# Application Comment Response Letter

## Verification of Administrative Relief:

Landscape plans

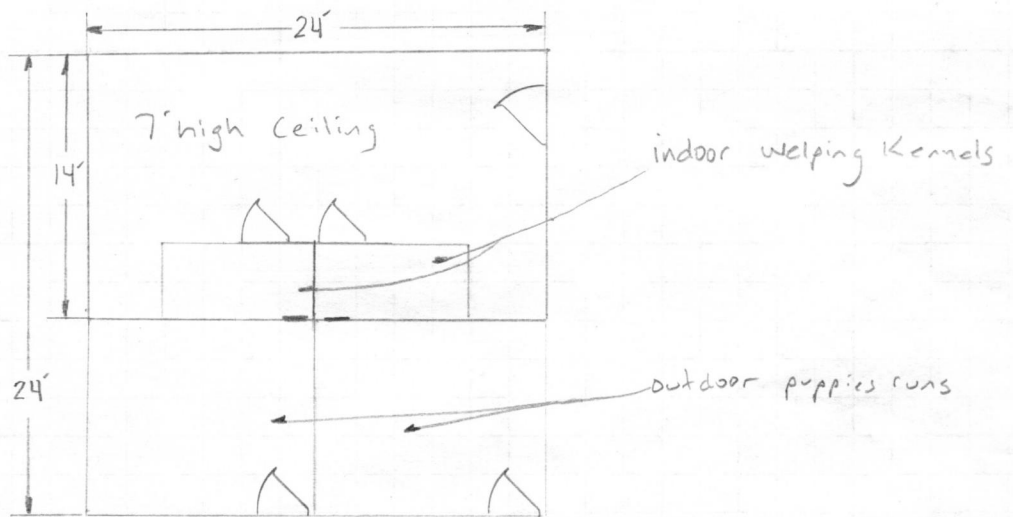
If landscaping cannot be met, this is where you will request an "Alternative Landscaping Design"

An Alternative Landscaping Design has been requested. We have strategically placed shrubs and a fence around the kennel house on the site development plan and drawing.
